Our Case Number: ACP-323066-25

Re: Gort Town Centre Public Realm Enhancement Project, Gort, Co. Galway
In the townlands of Gort, Co. Galway

Subject: Submission on the Proposed Gort Town Centre Public Realm Enhancement Project

PARKING ALLOCATION PLAN

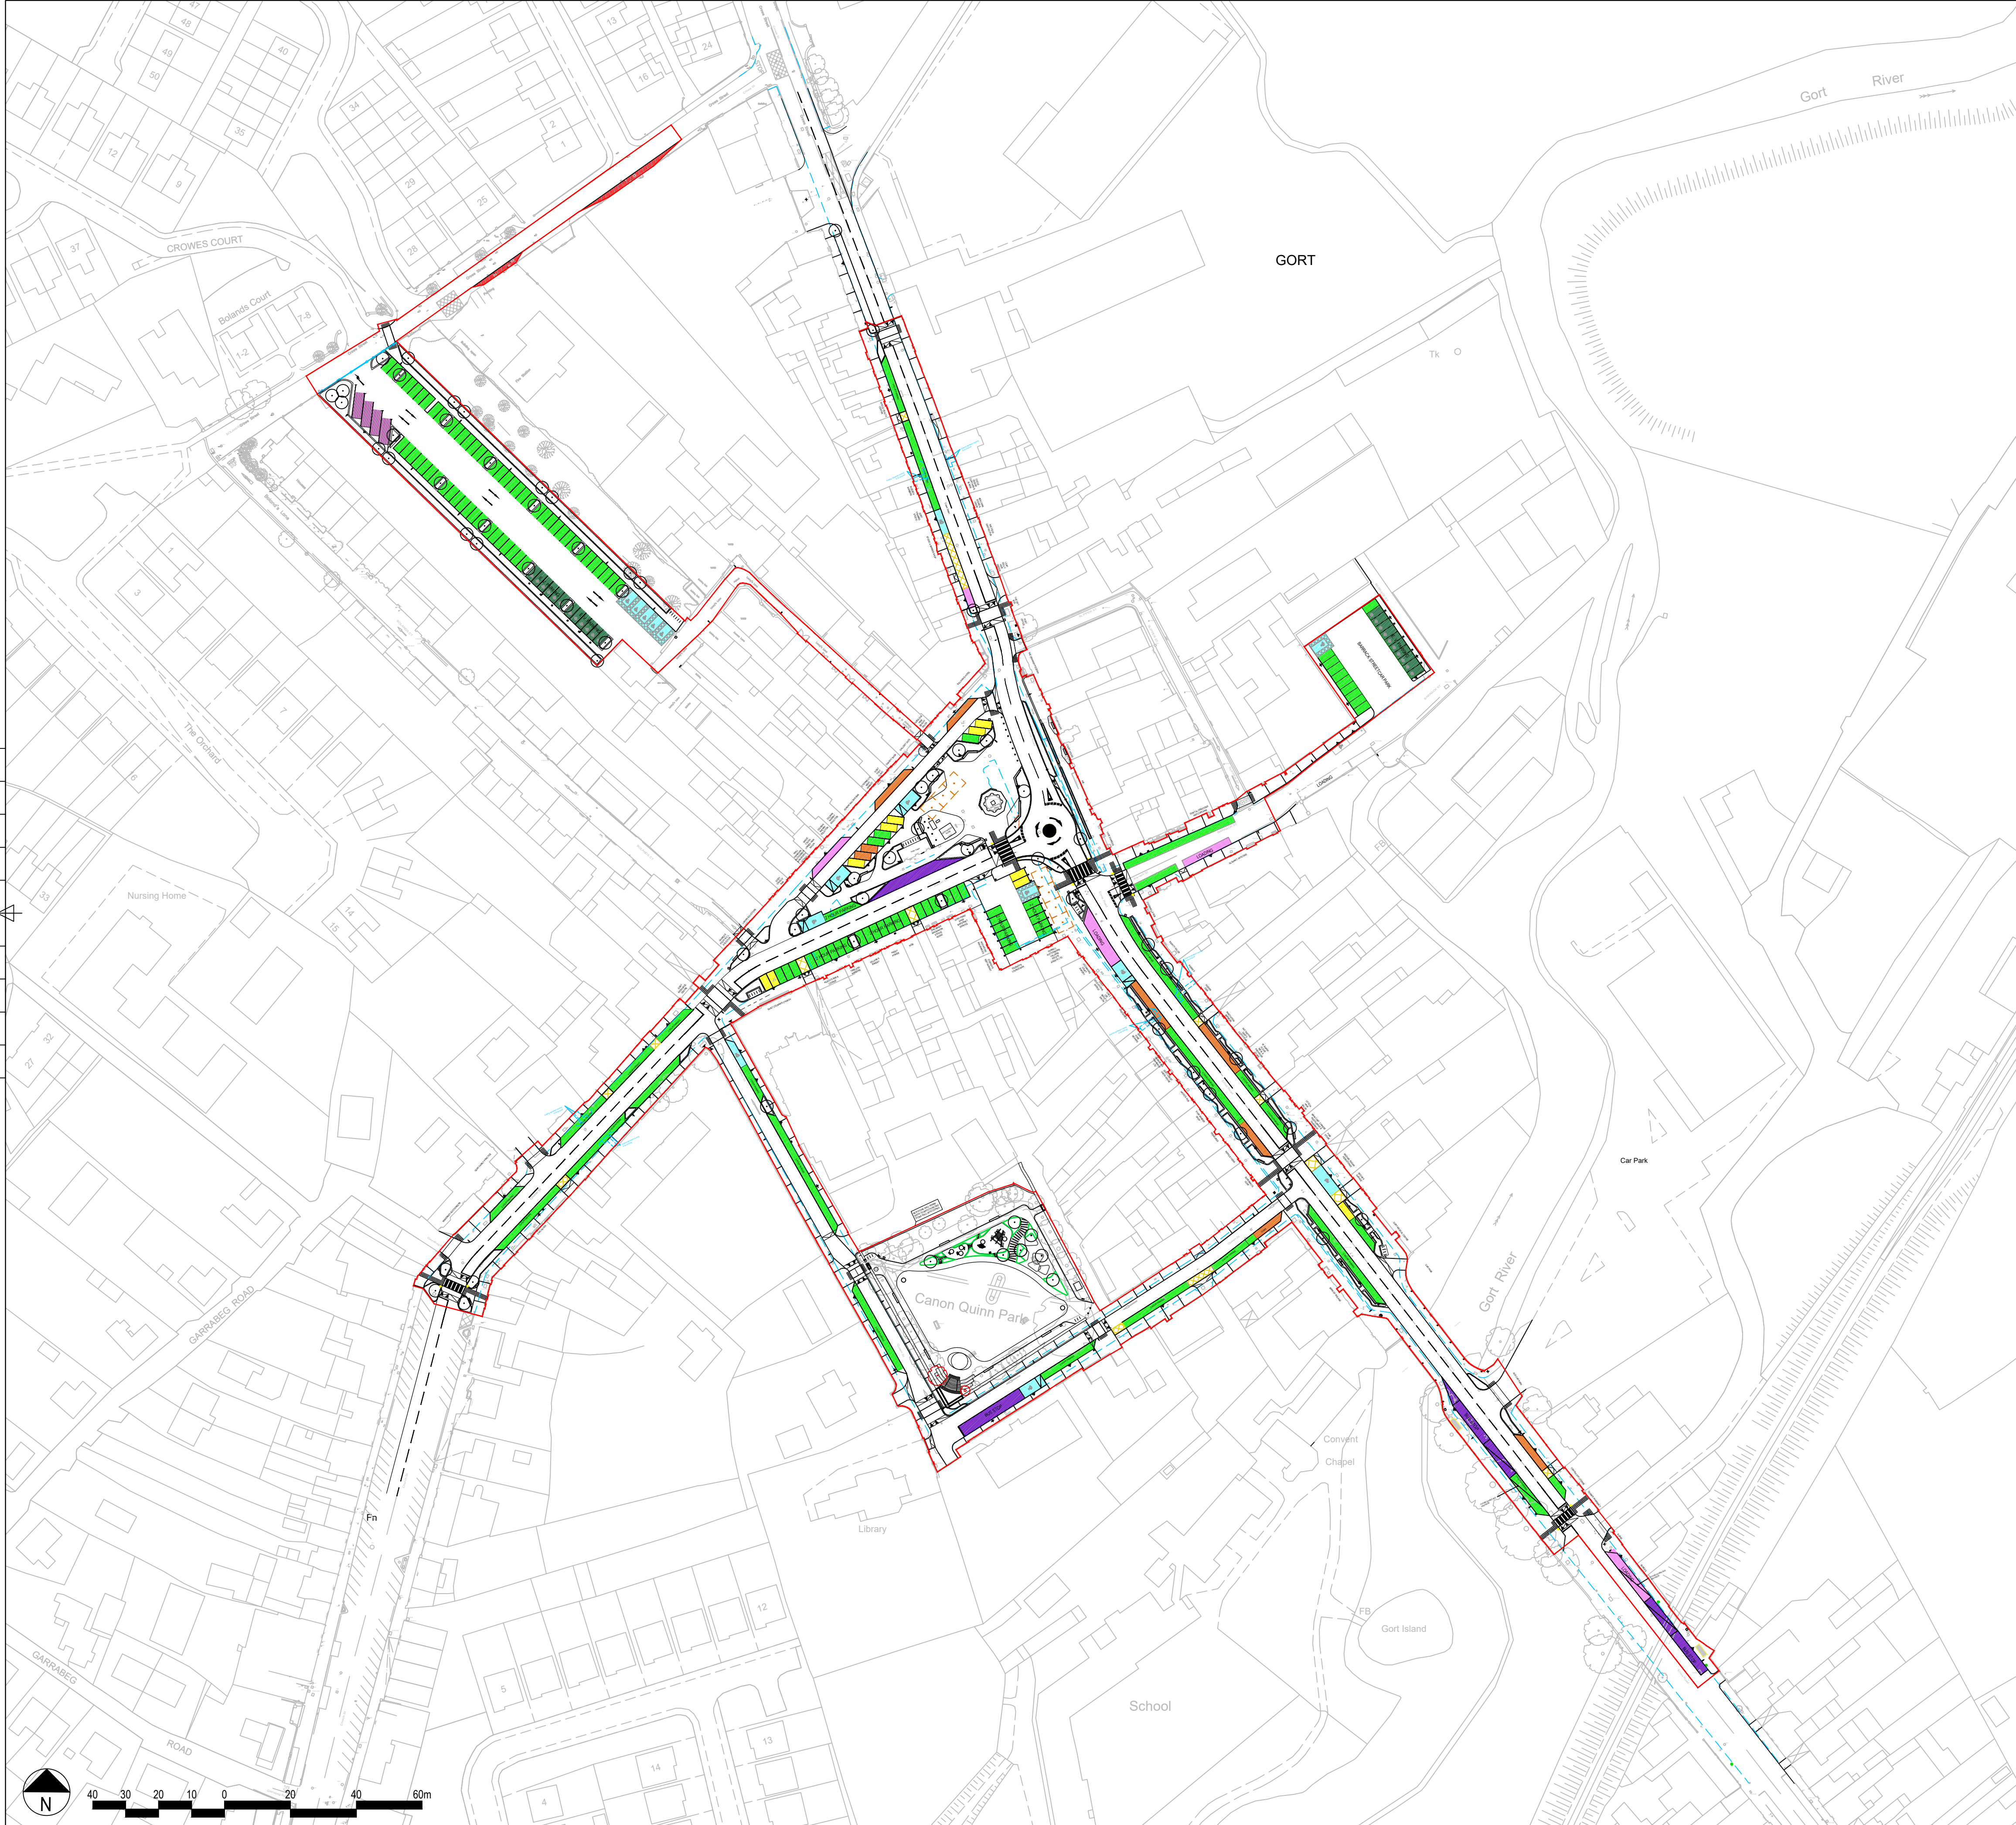
I am writing to formally express my concerns regarding the proposed Gort Town Centre Public Realm Enhancement Project, specifically the removal or reduction of on-street parking spaces in Market Square, Bridge Street, George Street, and surrounding areas.

Gort is a small town with limited parking infrastructure. Even under current conditions, customers often struggle to find convenient spaces. The proposed scheme, while positive in terms of urban design and aesthetics, does not adequately address the replacement of parking spaces being removed. This will aggravate an already challenging situation, pushing potential customers away from the town centre and towards larger retail areas with easier access.

1. Retain the majority of existing parking spaces directly in front of shops.
2. Explore alternative layouts that integrate greenery and pedestrian zones without eliminating essential parking.
3. Ensure that any parking removed is replaced with equivalent or greater capacity in close walking distance to the commercial streets.
